From: Chris Ingram [REDACTED]
Sent: 27 January 2014 10:55
To: Susan Leeson
Cc: Chinery, Paul
Subject: RE: FP/235/13/A
Attachments: 35511 DWH SOTH Manor Farm-v4.pdf

From: Susan Leeson [<mailto:Susan.Leeson@arun.gov.uk>]
Sent: 22 January 2014 14:30
To: Chris Ingram
Subject: FP/235/13/A

Project:
FELPHAM
WEST SUSSEX
PHASE 5.A, REPLAN
Drawing Title:
SALES ARENA.

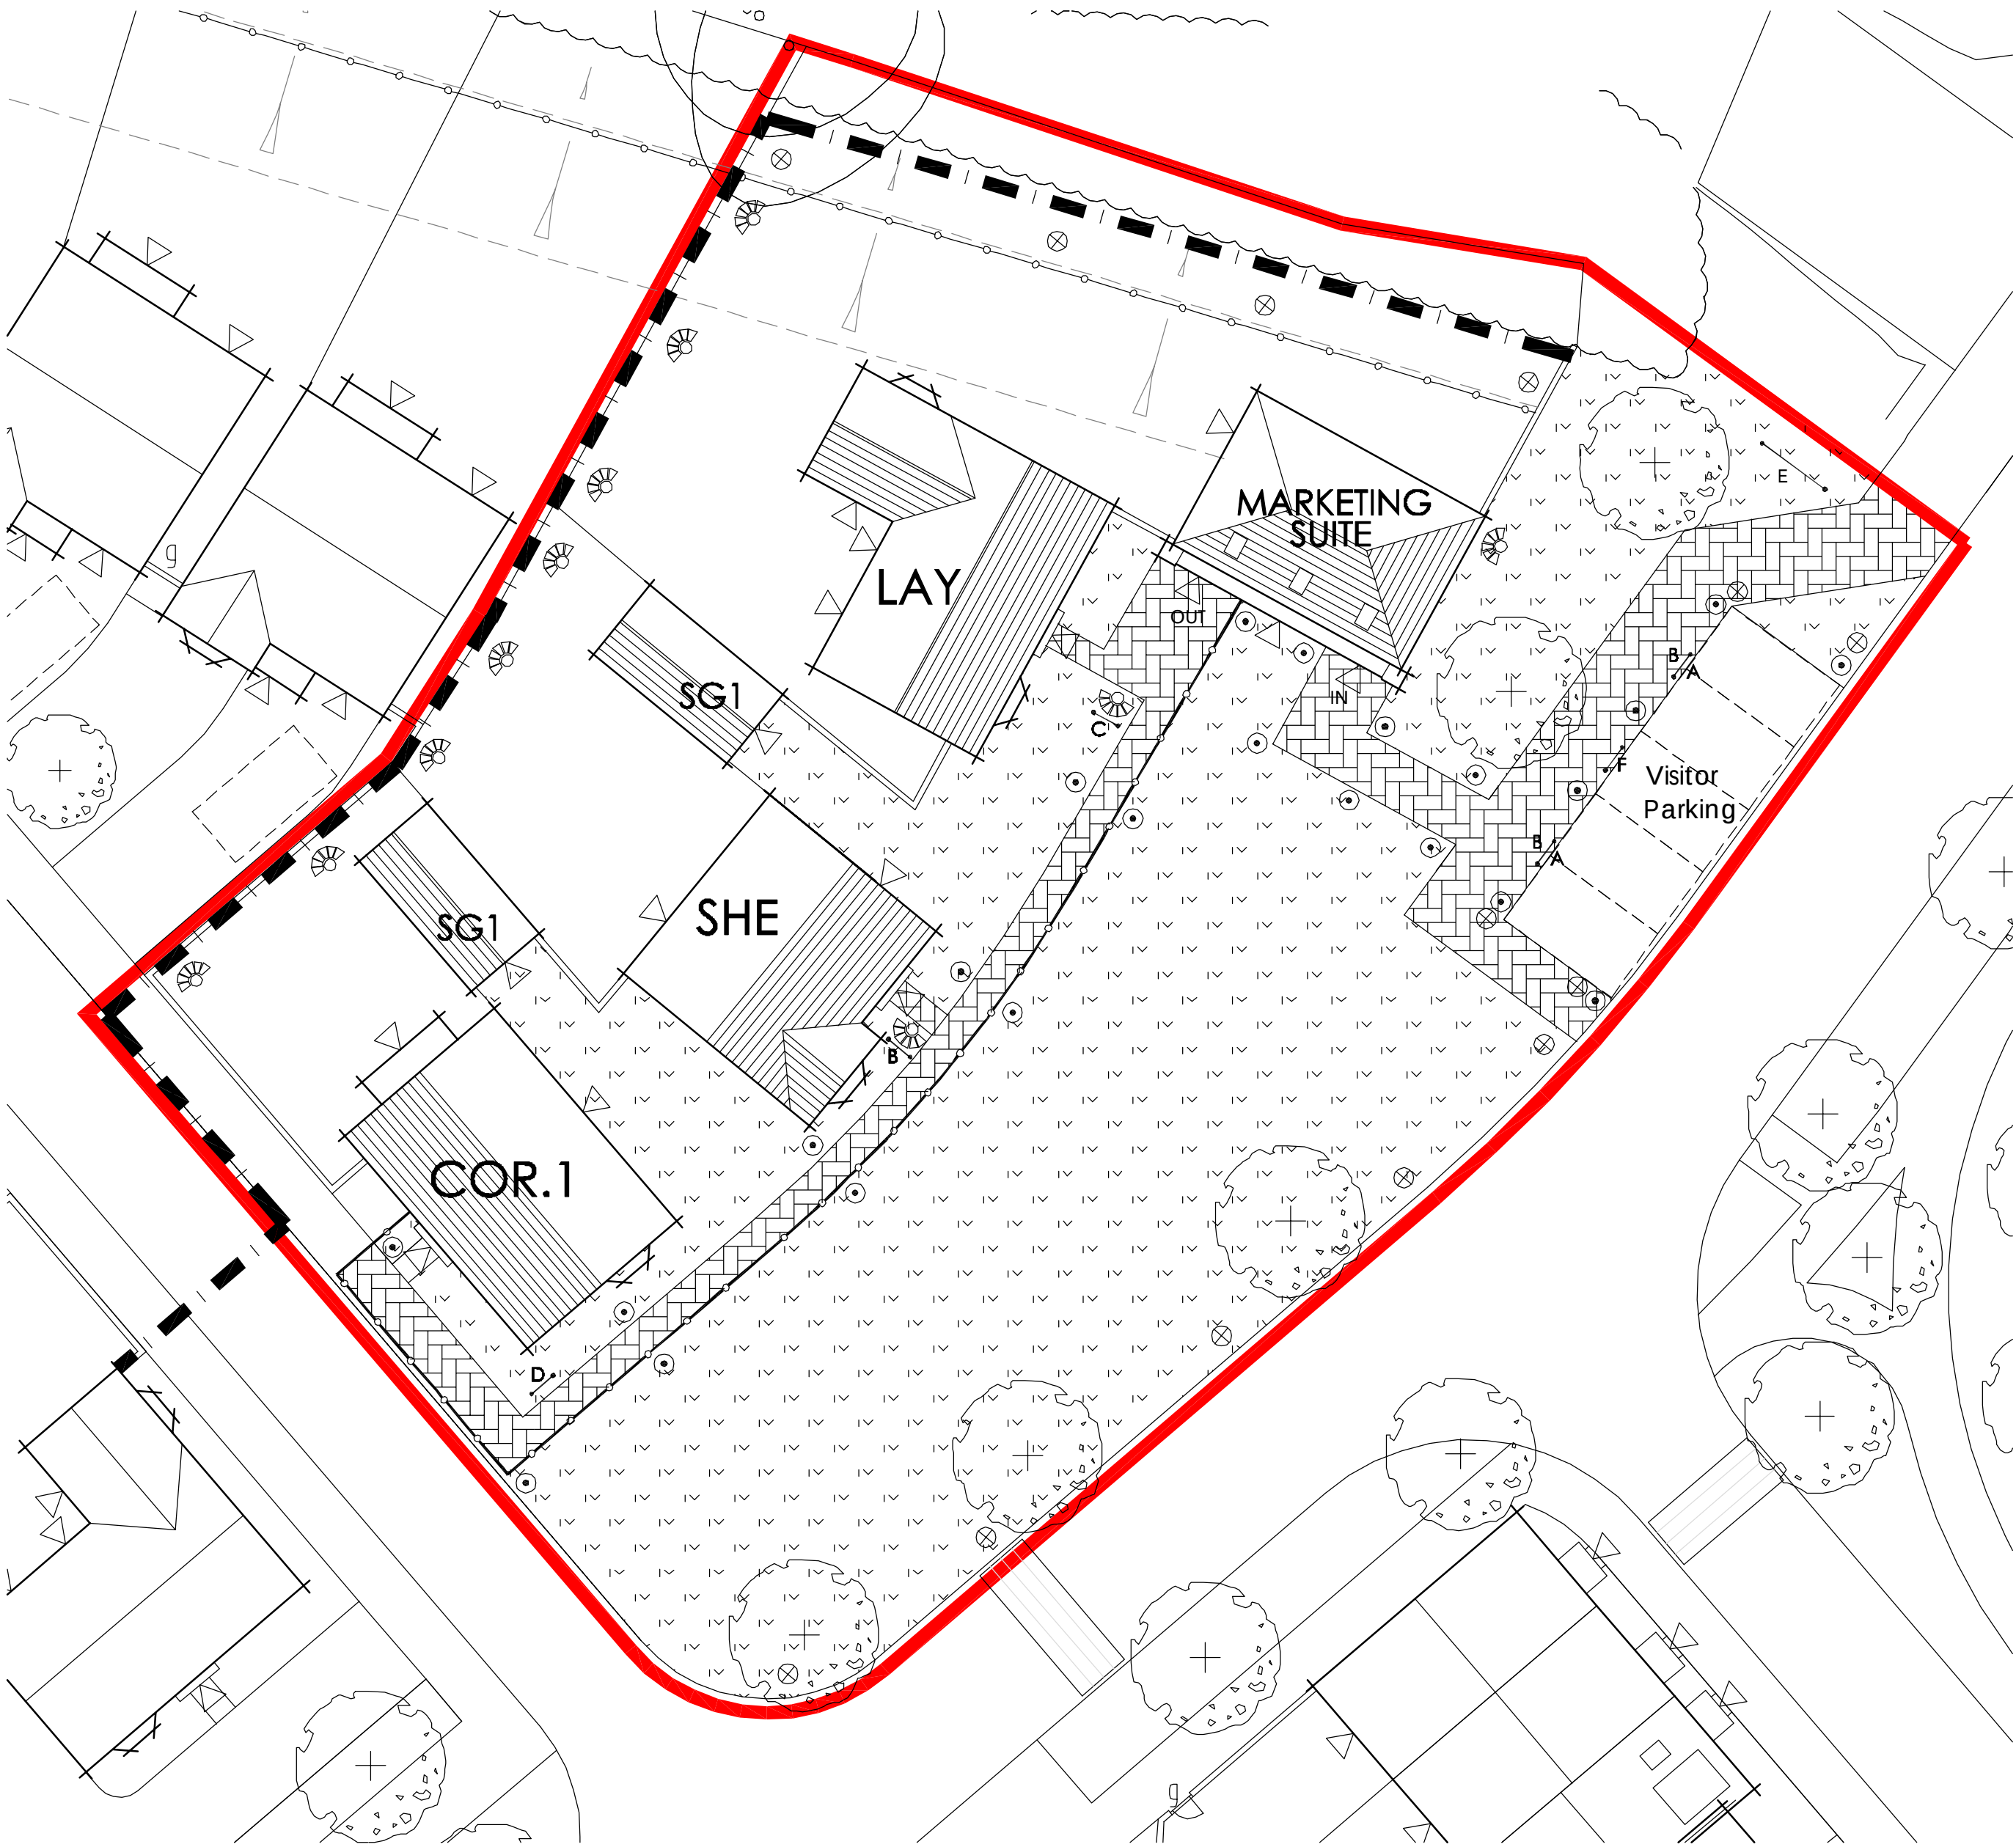
In order that I can progress your application, please can you send me a plan showing details of the flag poles and sign types A, B, C, D, E and F, the only detail I have is of the fascia sign.

Our client is in the process of receiving details of the proposed signage from their supplier. We will forward this upon receipt. In the meantime we have attached details provided of similar signage for another site.

Drawing Title:
MARKETING SUITE
ELEVATIONS AND PLAN

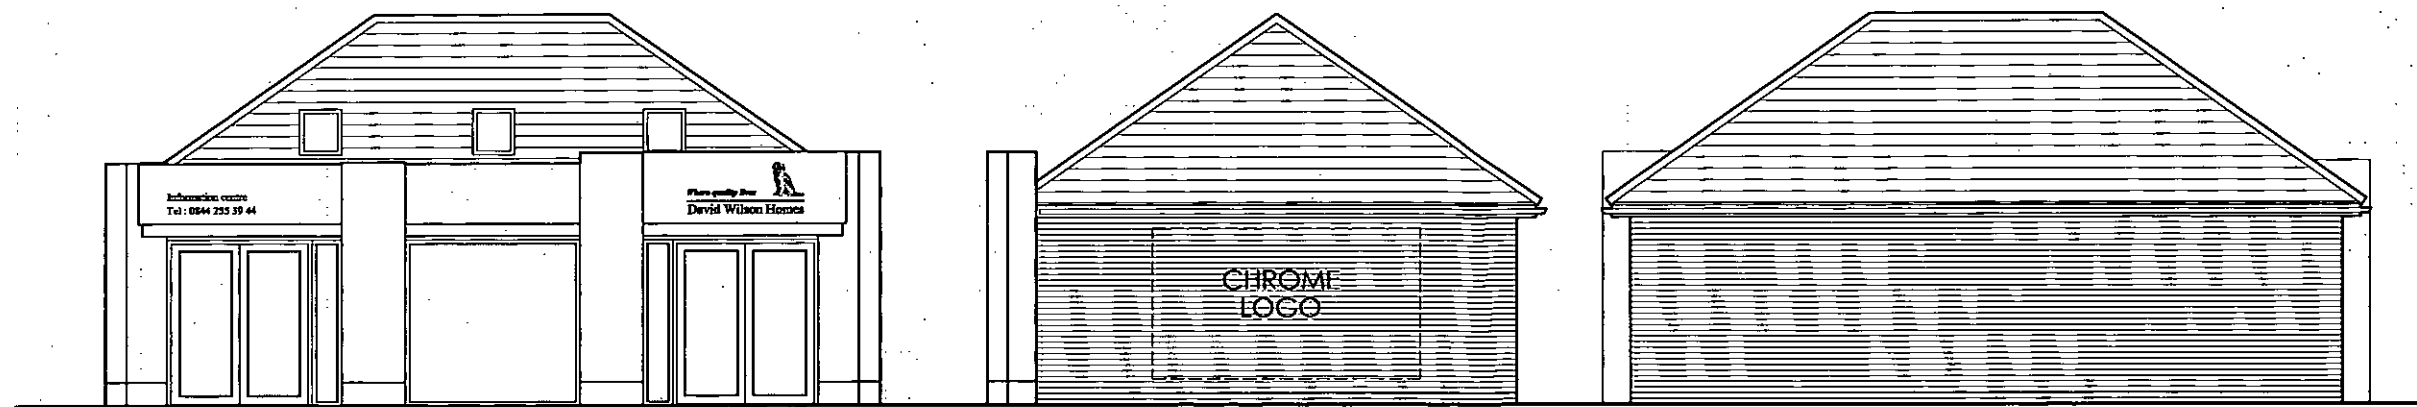
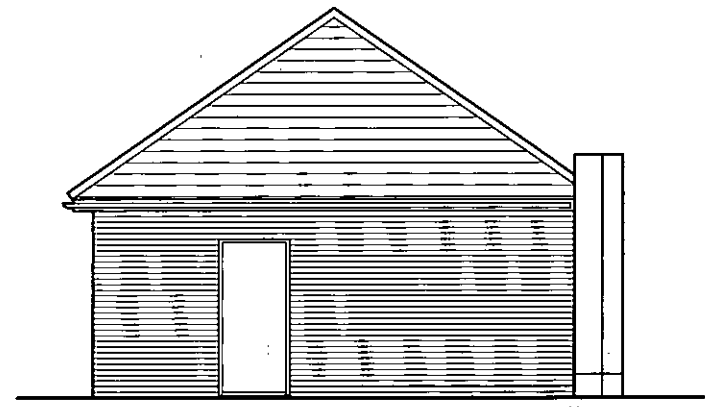
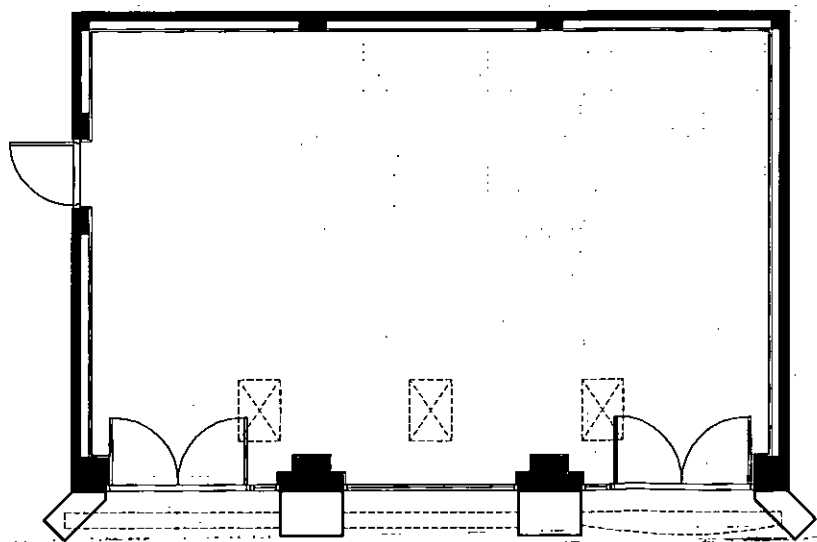
On preparing this we have noted that the detail description of the signage and the marketing suite is based on the Barratt Homes colour scheme, white on green. This should in fact be for David Wilson, white on blue. We shall amend the forms and marketing suite drawing and reissue. We hope that this will not cause any undue inconvenience.
